RECORD OF THE PRE-DEVELOPMENT APPLICATION MEETING

Date/Time of meeting: 25 March 2024, 10:00am

Property: 57-61 Archer Street & 34 Albert Ave, Chatswood

Description of Proposal: Construction of a shop-top/mixed use building.

BASEMENT 5

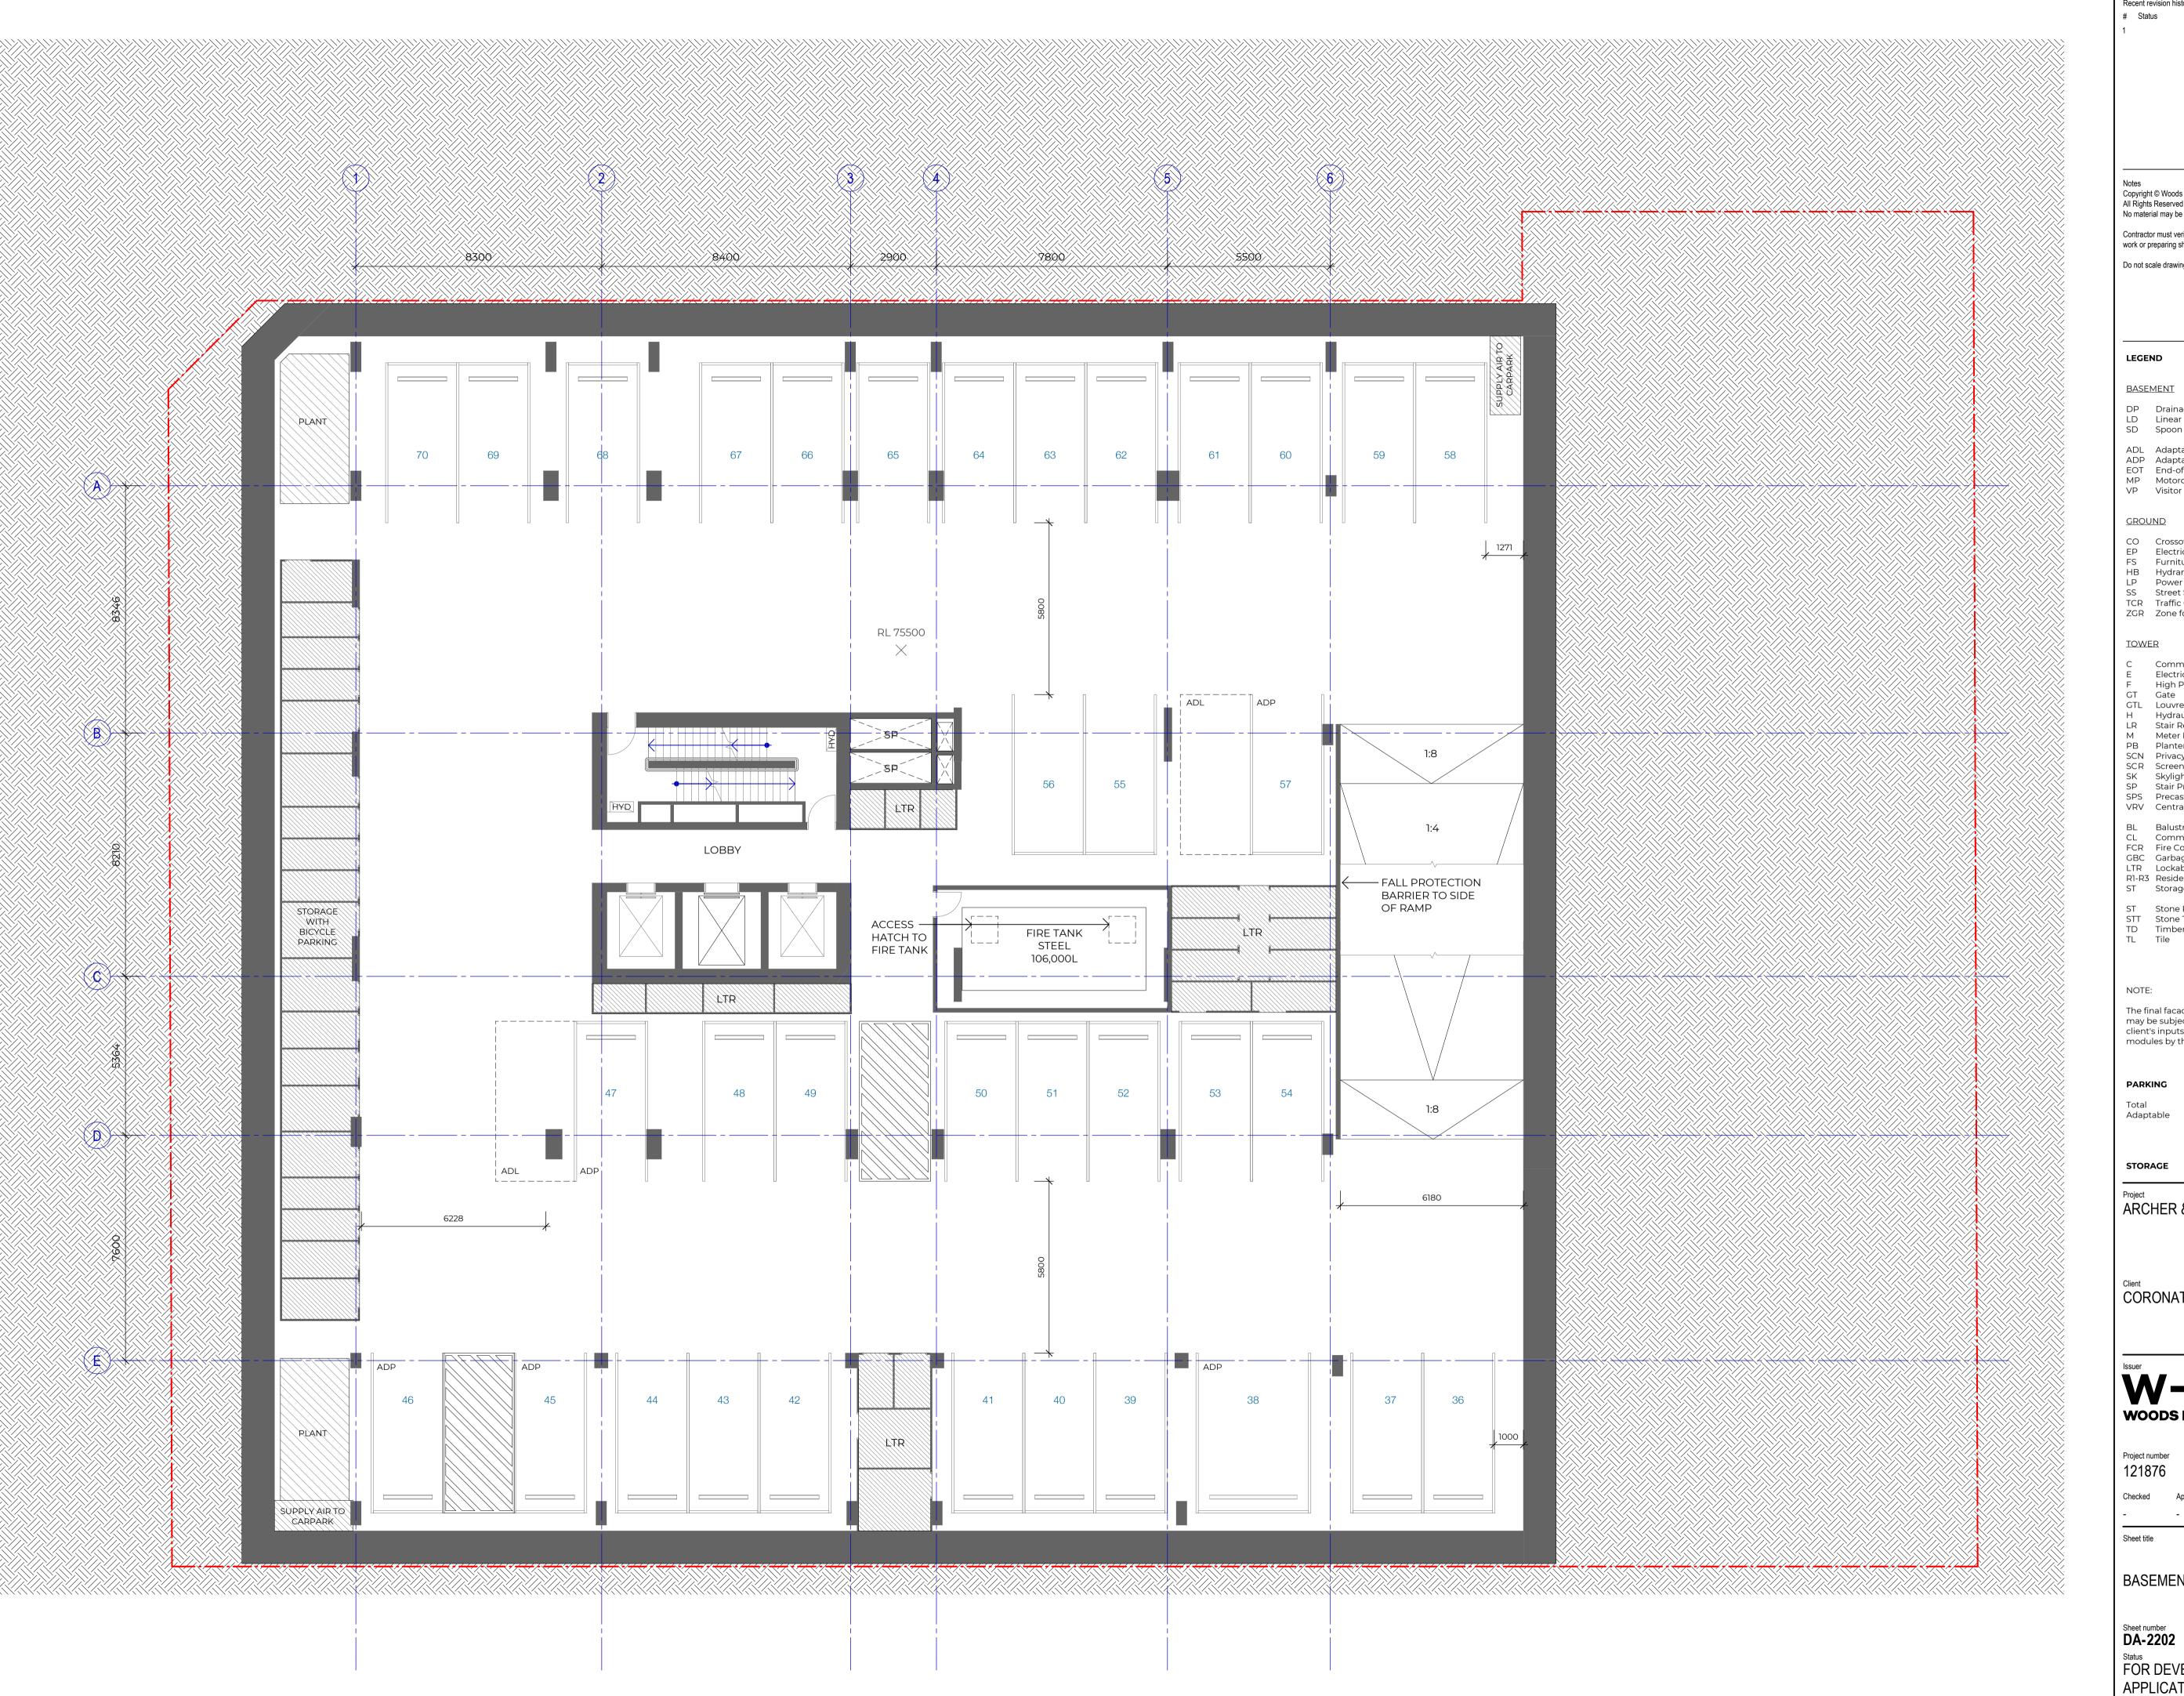
- Details for the sewer line will be required as part of the DA. We need to see if the relocation is feasible with the proposed basement design. This also applies for Council's Stormwater.

- Base on the limit info. the parking seems to exceed Council's maximum. Parking rates are to comply.
- A question was raised about using the roof top communal spaces as an integrated space potentially with a health/gym use. Council have considered and believe that the use conflicts would create issues. Noting that families

BASEMENT 1

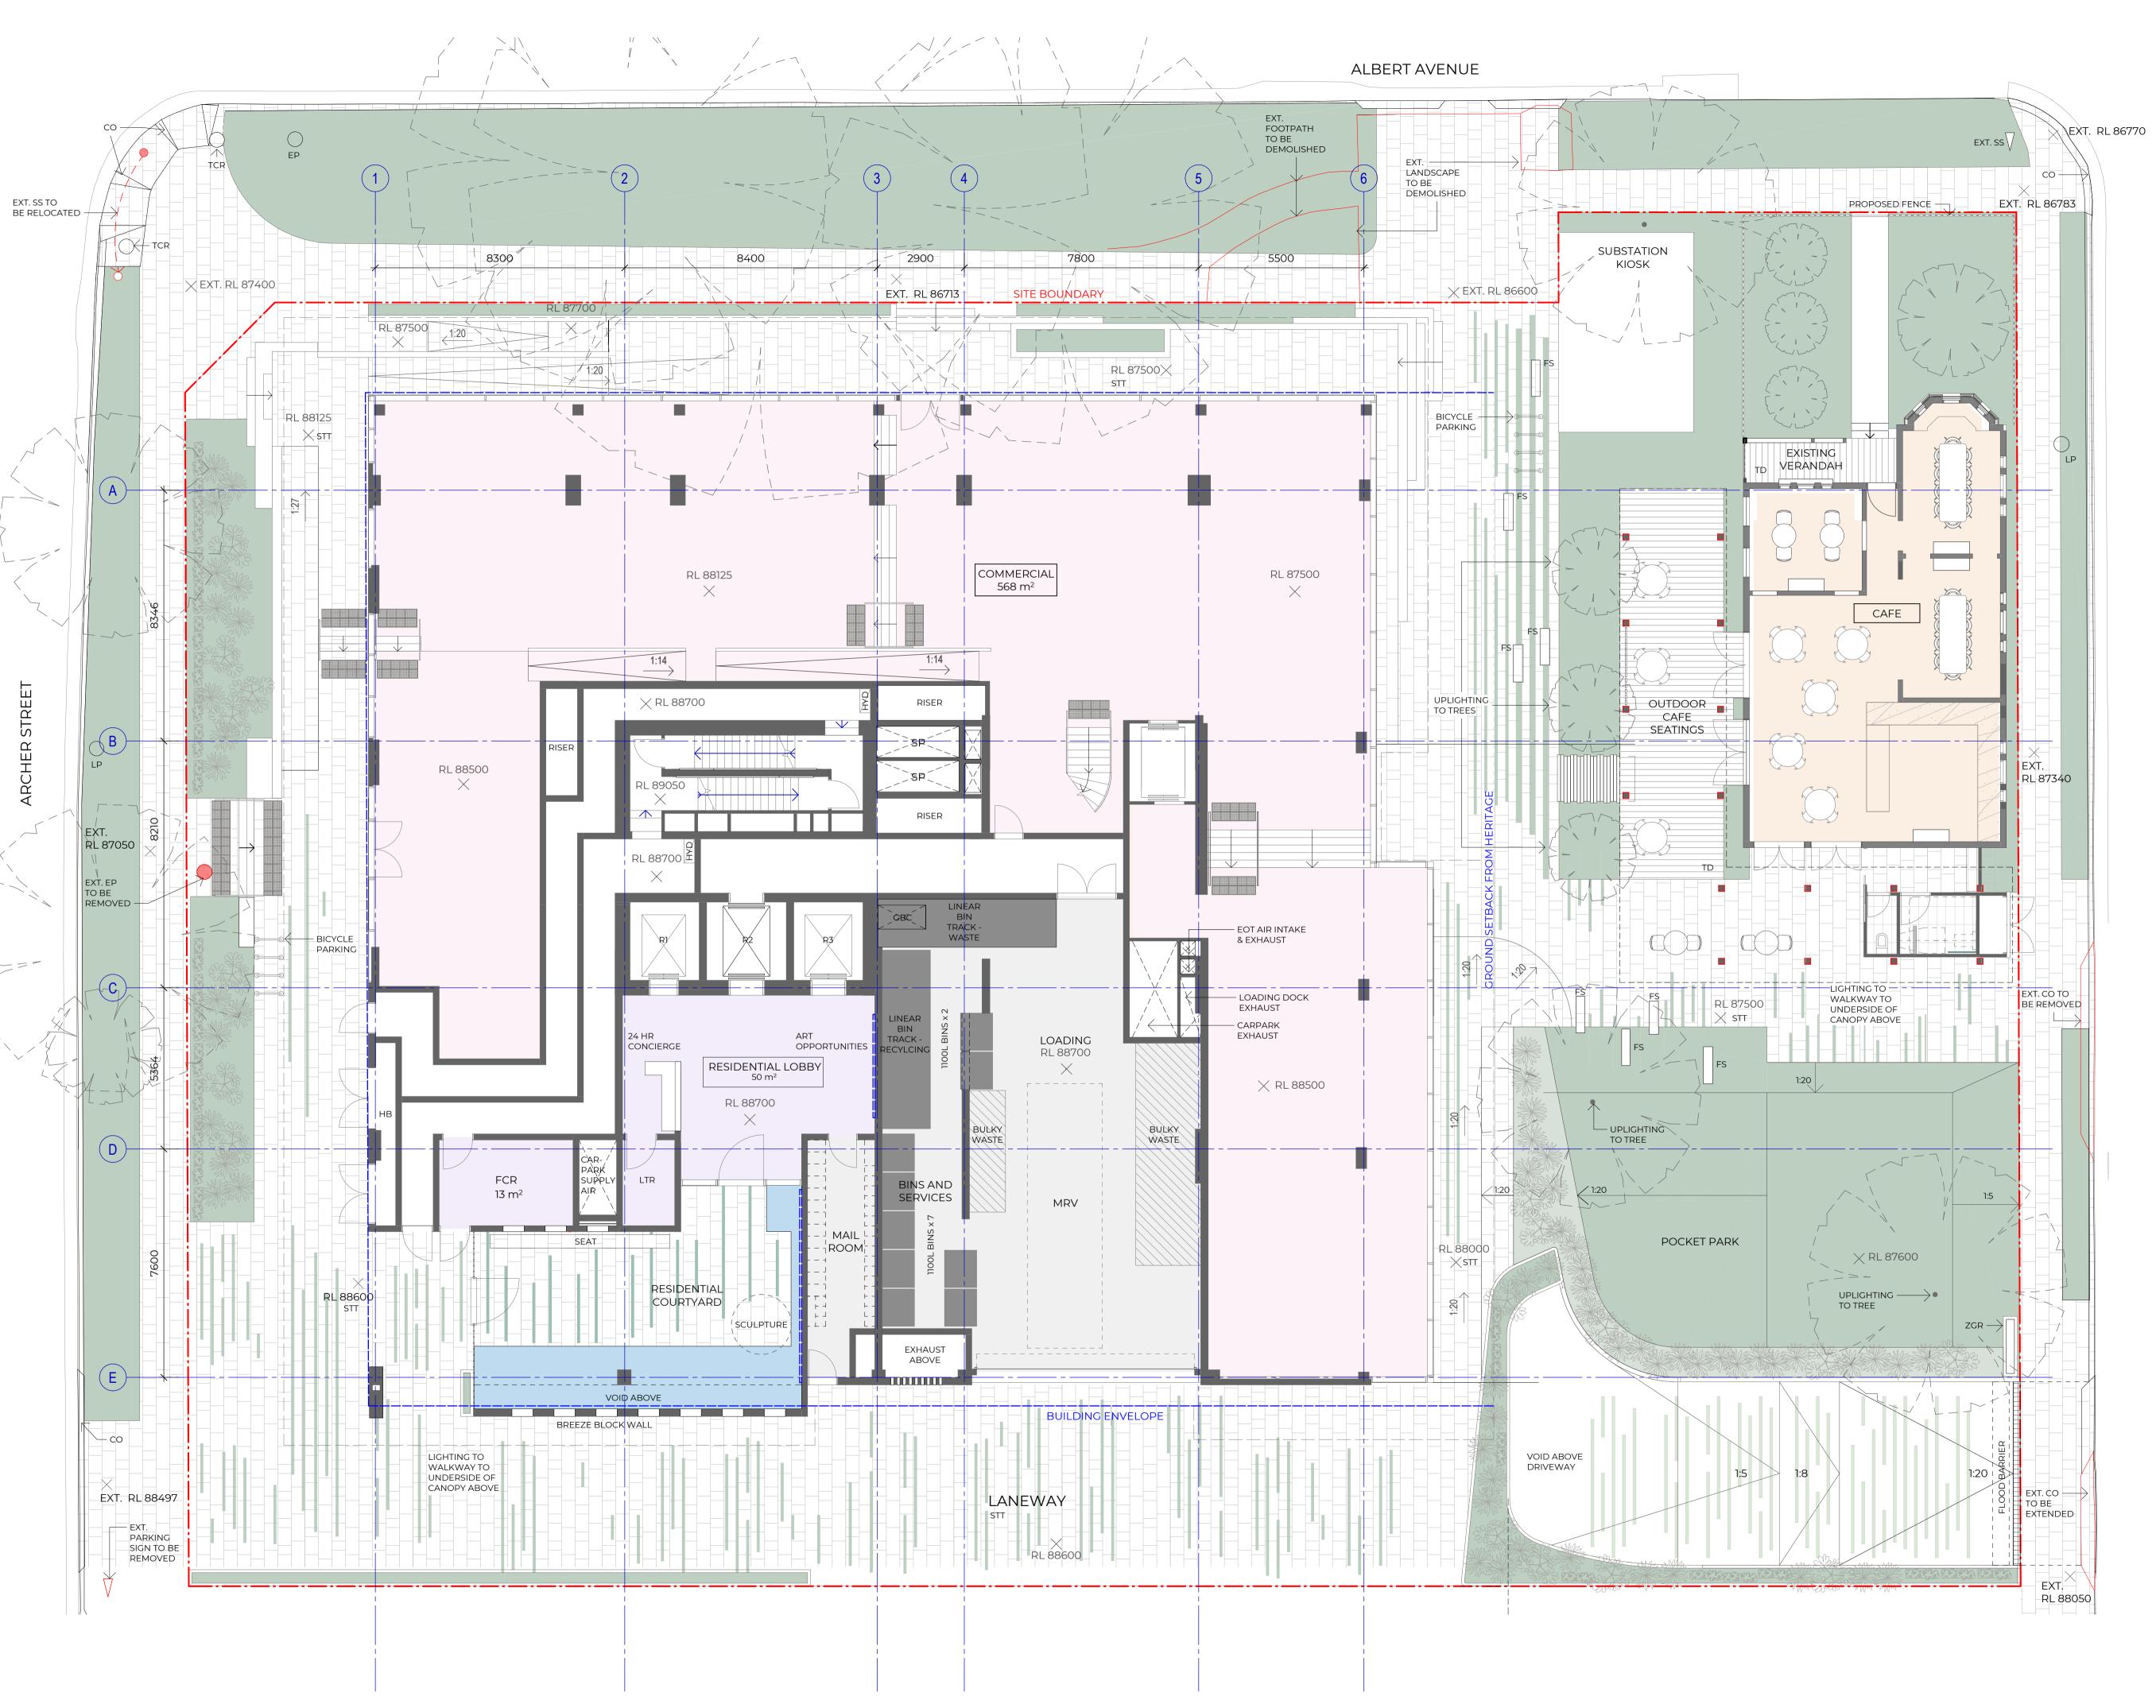
Parking spaces for adaptable units need to comply with the requirements of AS/NZS2890.6. Headroom at the spaces is to be detailed on the plans or sections to confirm compliance.

Plans for the parking areas must include sufficient dimensions to confirm compliance with the Australian Standards, including aisle widths, typical space lengths and widths, ramp grades and sight distance triangles at the exit.

SUB-PENTHOUSE
LEVEL 29-30

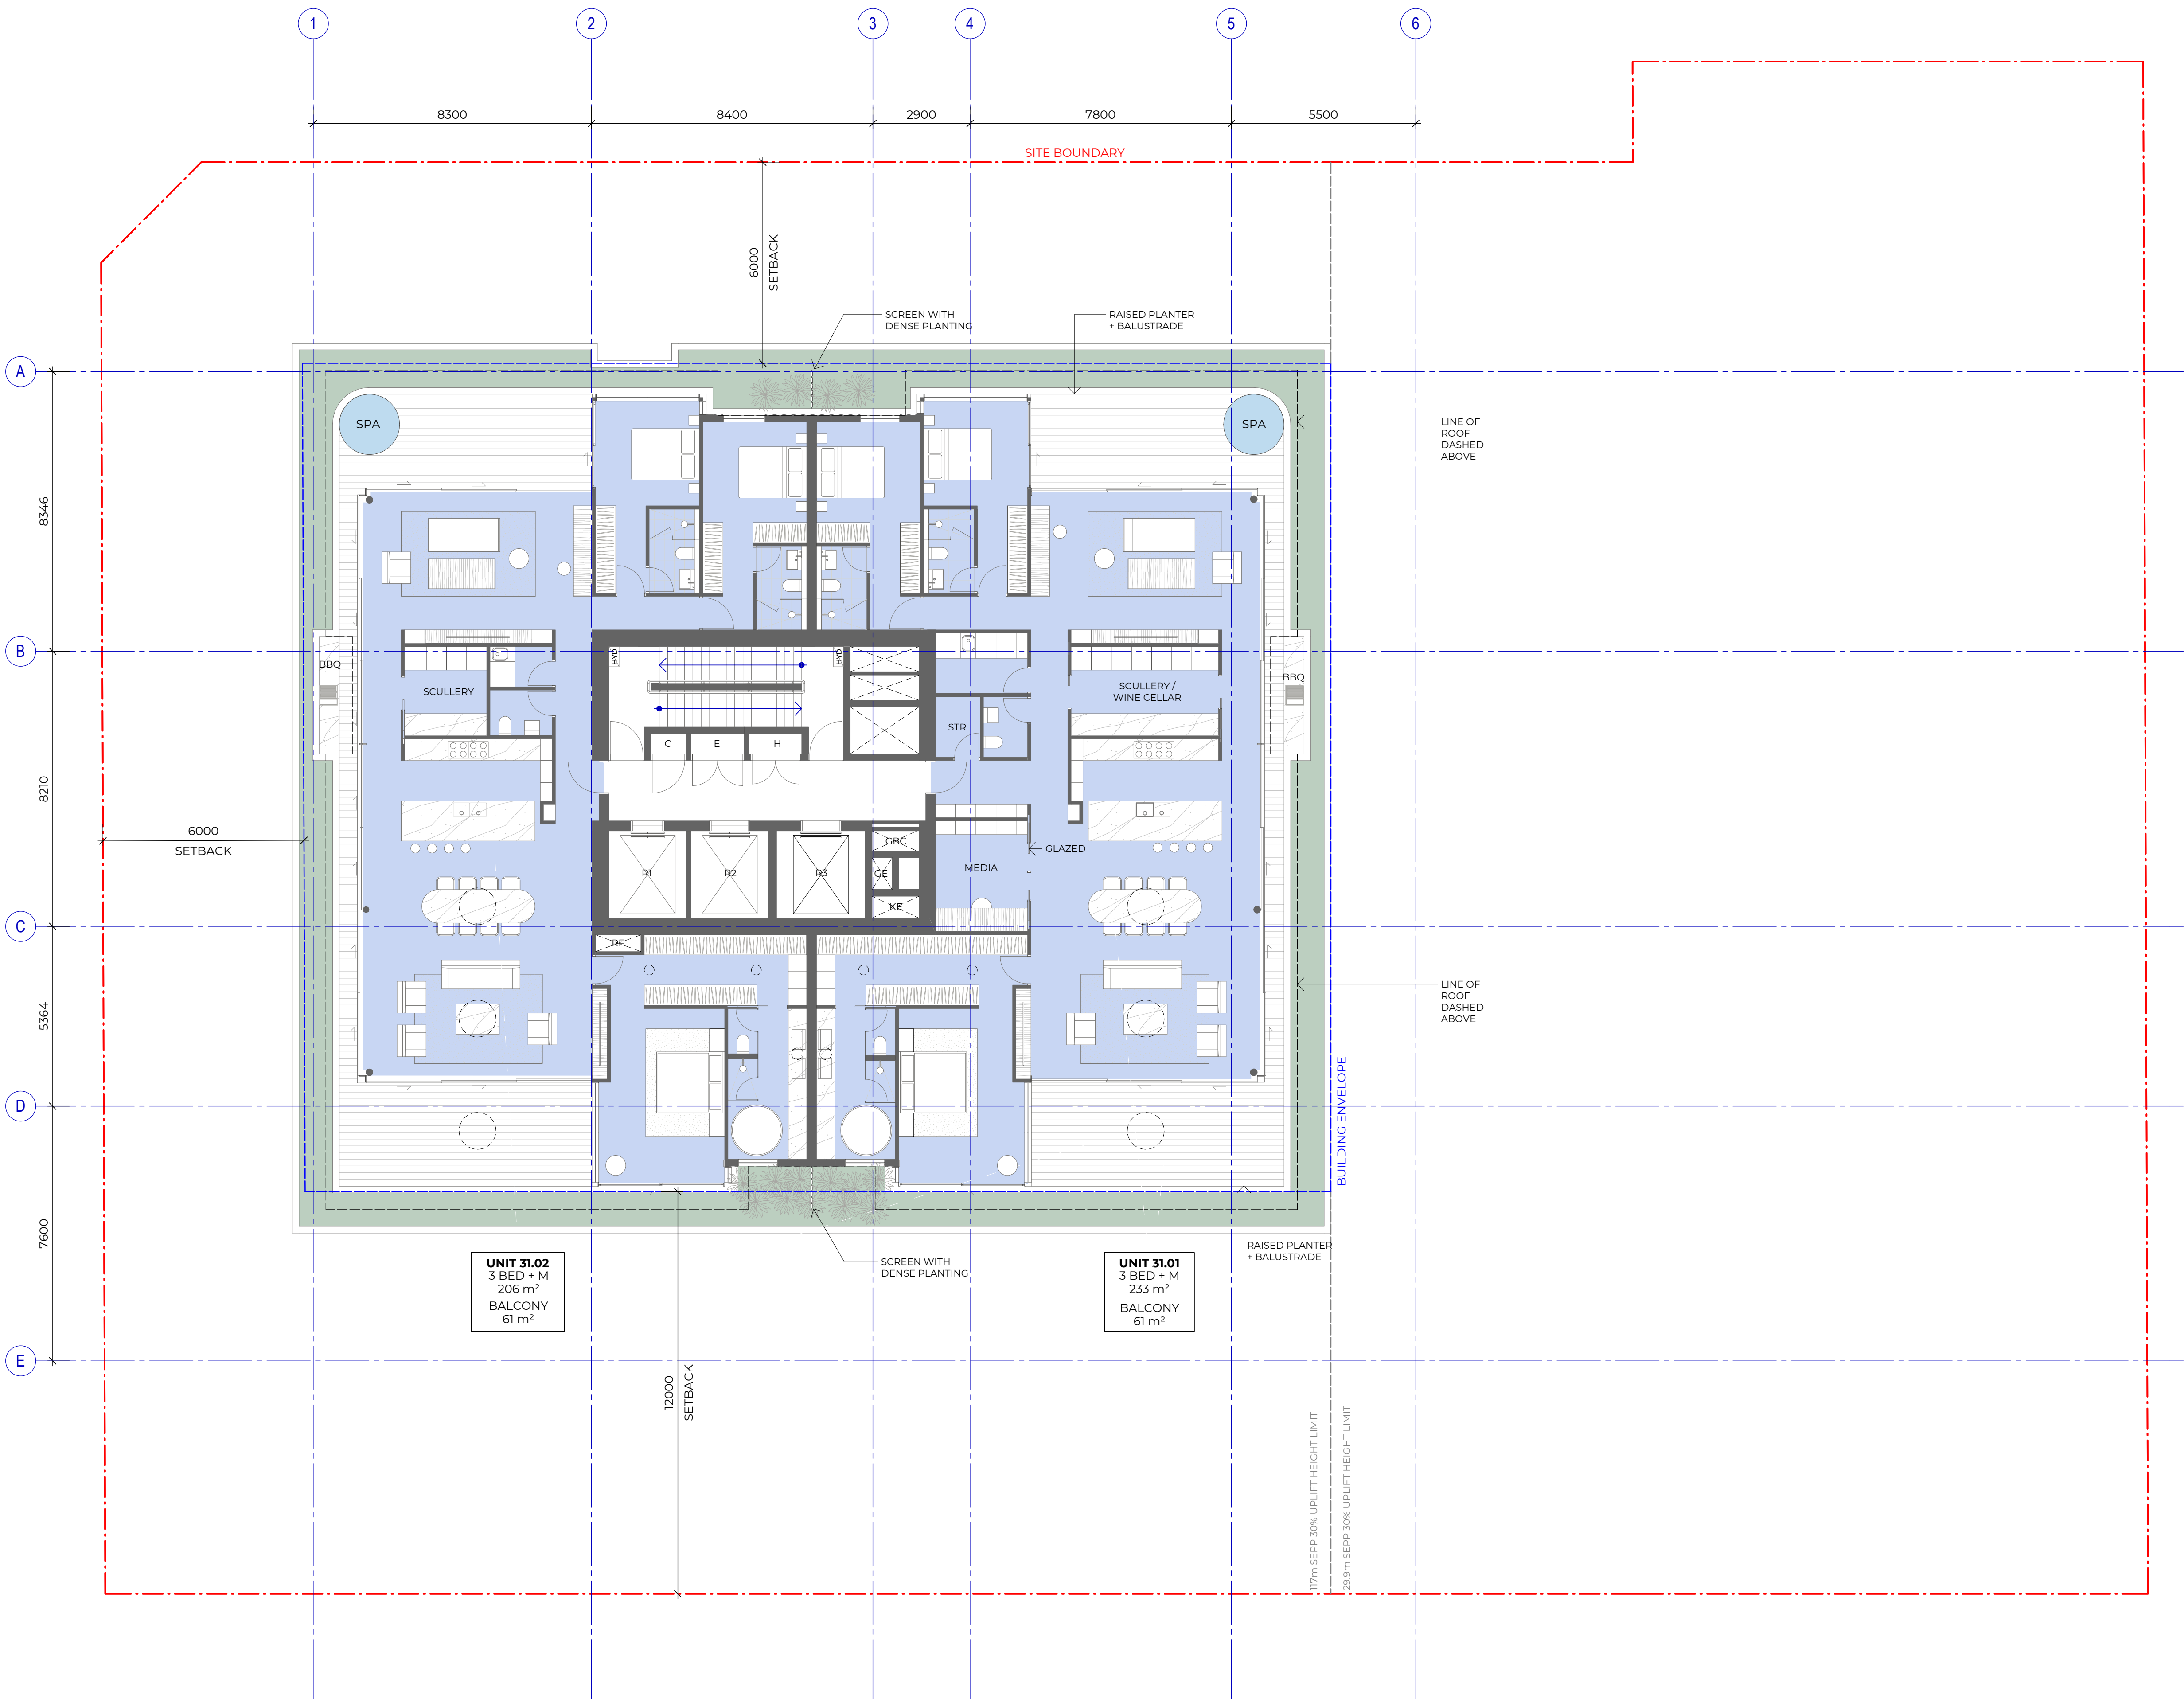
- The penthouse on top with communal space raises some use and amenity conflicts. Not an objection outright, but needs further thinking.
- Limited floor plans provided, however some units with minimal solar compliance seem to have lesser amenity. Understanding these are draft plans I leave this comment here.
